RE: Harnett County Land Use Application HTE 08-5-19298R

Lt 151 Forest Oak

An attempt was made to evaluate your property for the purpose of issuing an Improvement Permit. The evaluation could not be completed for one or more of the following reasons.

- PLOT PLAN FOR -
 CAVINESS LAND
 - SUBDIVISION -
 FOREST OAKS-PHASE THREE
 ANDERSON CREEK TWP. JUNE 3, 2008
 HARTNETT COUNTY SCALE 1" = 50'
 NORTH CAROLINA FIELD BOOK
 REFERENCE
 PLAT BOOK 2007, PAGE 447
 HARTNETT COUNTY NORTH CAROLINA REGISTRY

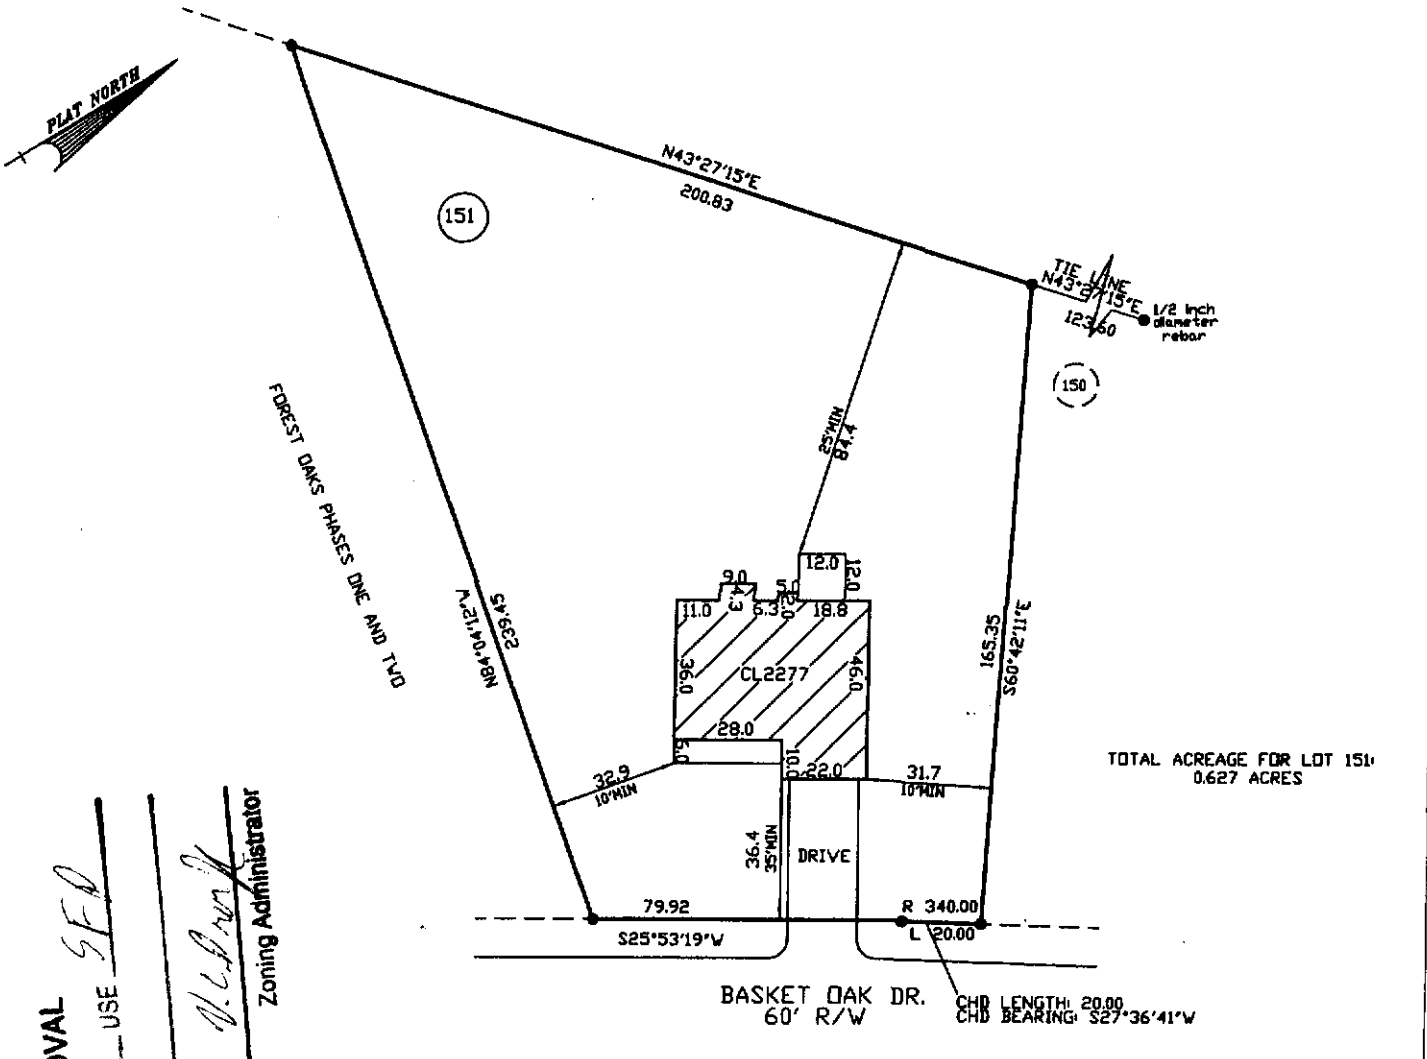
- 1. Property lines/corners not marked or labeled ~ **\$25.00 fee incurred**
- 2. House corners not marked or labeled ~ **\$25.00 fee incurred**
- 3. Directions not clear to property ~ **\$25.00 fee incurred**
- 4. Property needs brush or vegetation removed
- 5. Backhoe pits required
- 6. Other - **reduce the home to 3 bedrooms, shift home as shown on attached**
